Aldington and Mersham Support Group Submission for Deadline 6 (29th April 2025)

Drawing Title:
 Traffic Regulations
 Measures Plan
 Sheet 4 of 7

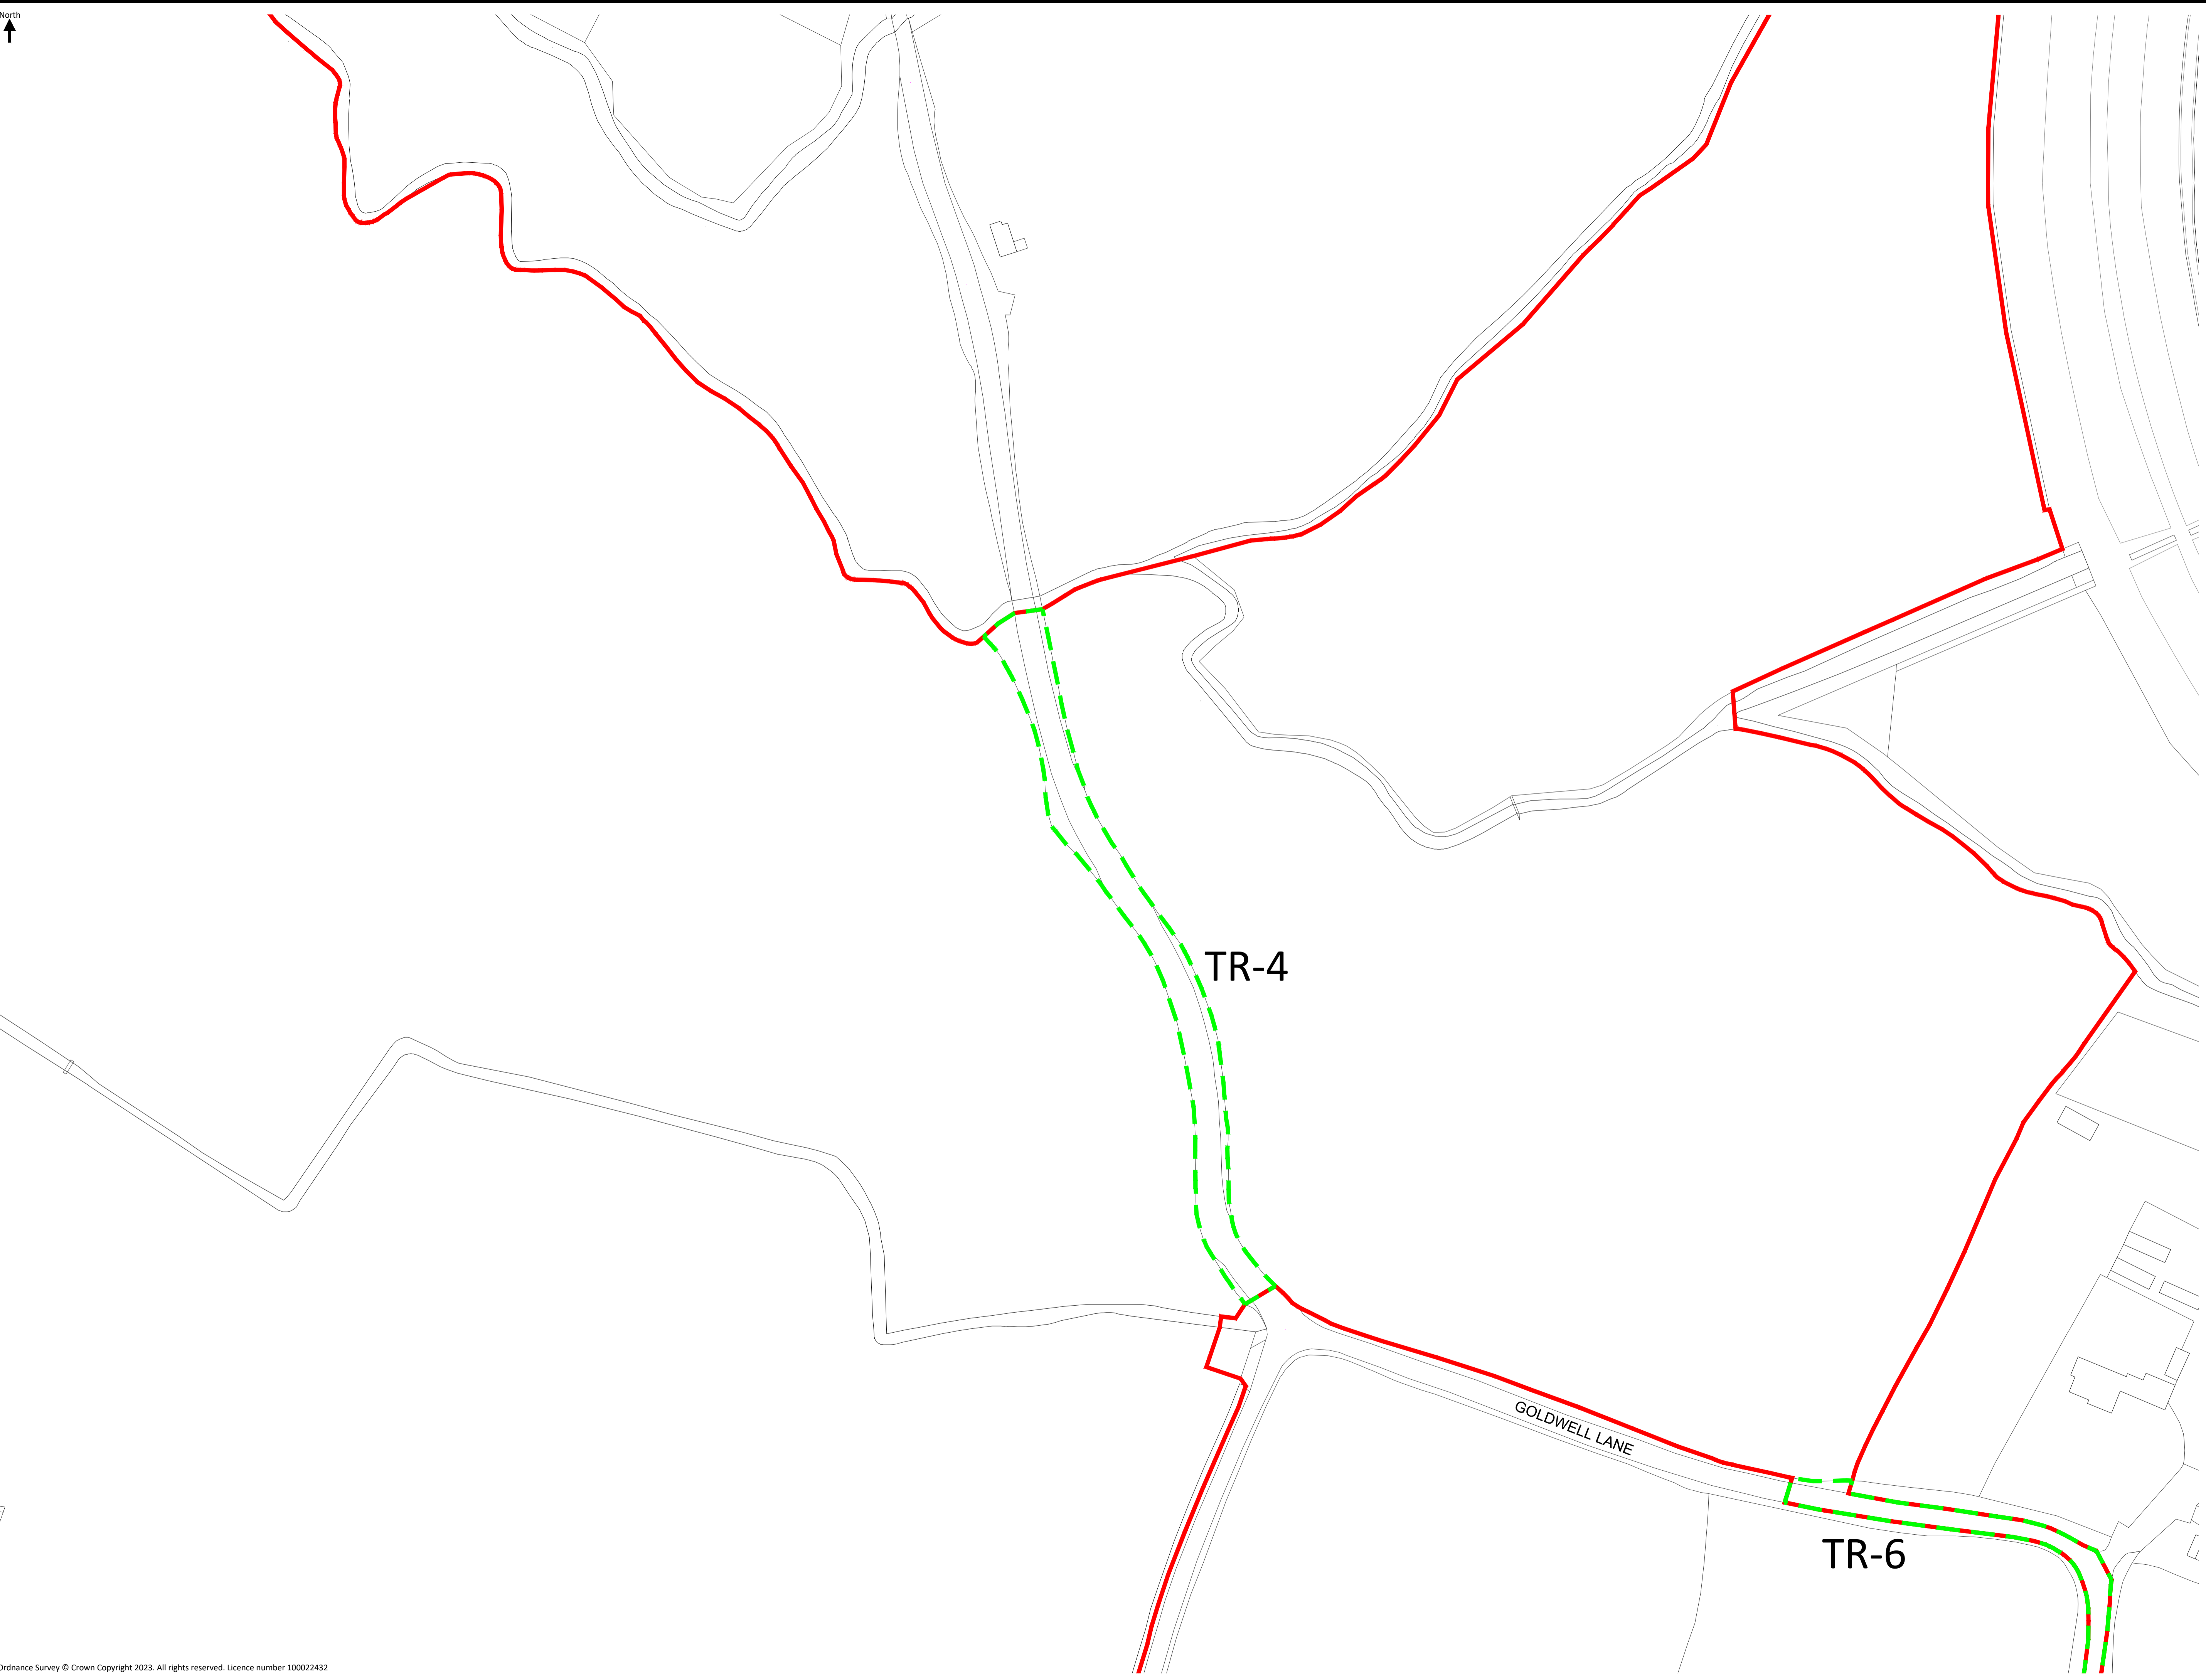
<p>We have maintained throughout this process that the Smeeth Crossroads (A20 junction with Station Road) is very dangerous and stands to be made much more so during this project if consented due to a substantial increase in traffic movements (because the minibus plan will not work) and because of articulated lorry deliveries.</p> <p>It is difficult for two such lorries to wait in the lane to turn right and the second of these will potentially interfere with fast moving eastbound through traffic.</p>	<p>The Applicant’s response to our contention remains that “<i>the ghost island has an effective length of 50m, which is long enough to accommodate three 16.5m long articulated HGVs</i>” (para 5).</p>	<p>We have taken measurements on site. From the end of the taper of the ghost lane (west end) which is the first point at which it can accommodate the width of a vehicle, to the centre line of Church Road/Station Road is exactly 44.8 metres. Three HGVs bumper to bumper requires 49.5 metres. They categorically cannot fit in it.</p> <p>The ghost lane is therefore at least 5 metres too short. Two HGVs is an absolute maximum and even then, the trailer of the second lorry is likely to be causing an obstacle to fast moving traffic eastbound. Even one extra car turning right will cause eastbound traffic to queue or try and mount the pavement to get round the obstruction.</p>
